March 9, 2006

Re: Status of Improvement Permit Application #06-5-14133

Phillip Thornton

River Ridge Lot 4C

SITE PLAN APPROVAL

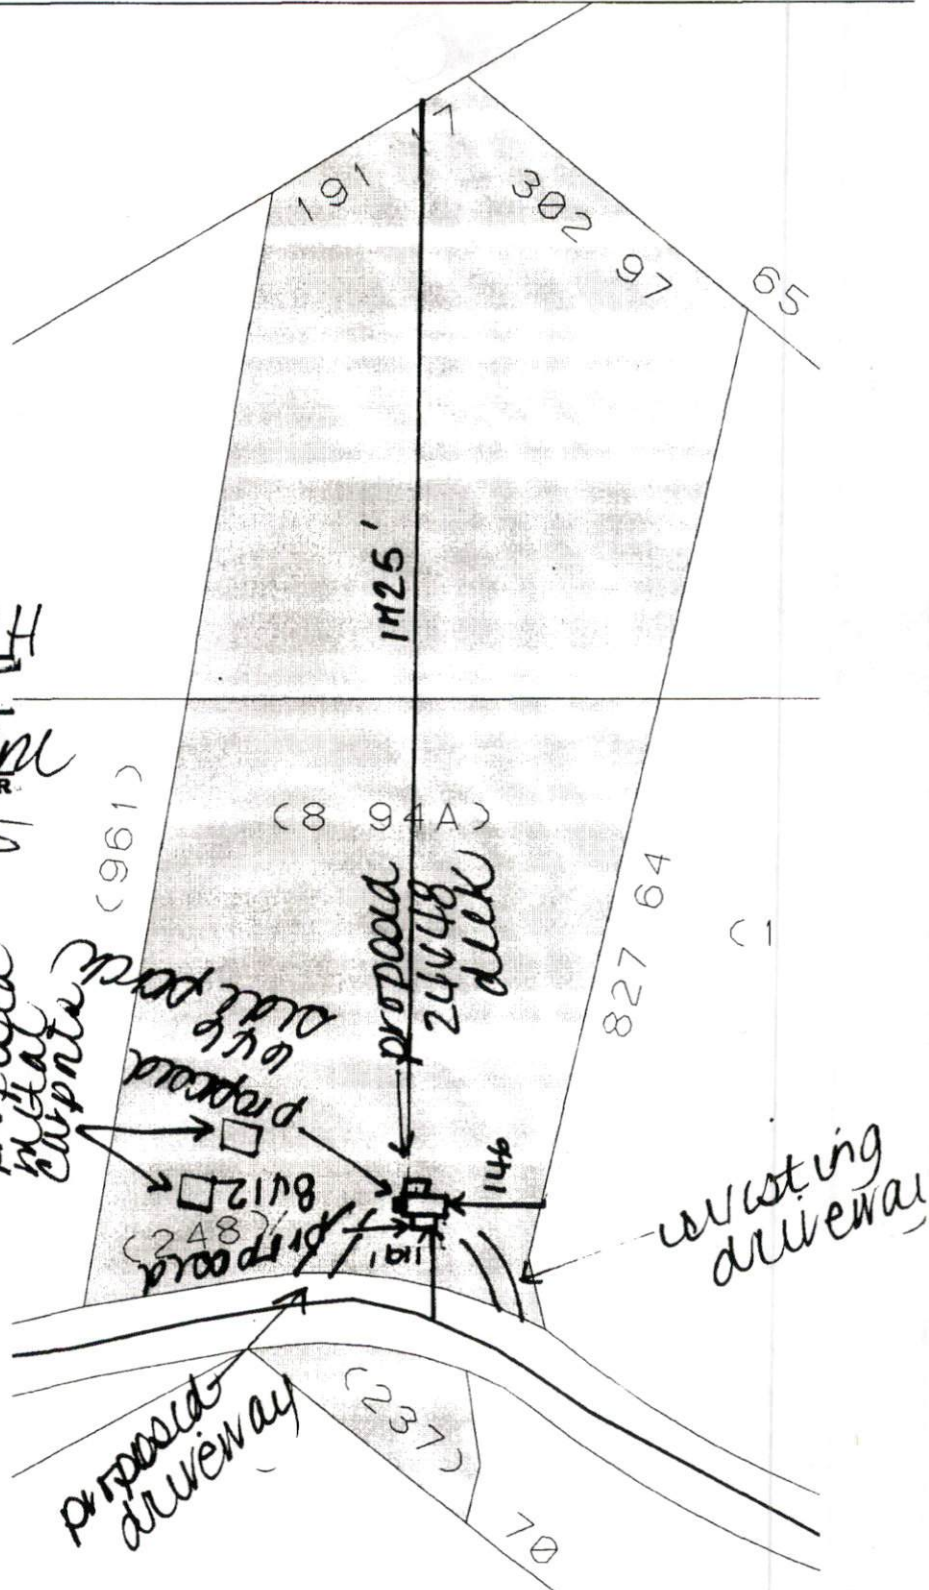
- 1. Property lines/corners not marked or labeled
- 2. House corners not marked or labeled
- 3. Directions not clear to property
- 4. Property needs brush or vegetation removed
- 5. Backhoe pits required
- 6. Other – **You will need to move house location as shown on attached page. Please make changes at Central Permitting and once their plot plan has been changed and resubmitted to me I can issue permits.**

Howe can go Anywhere Outside This Area
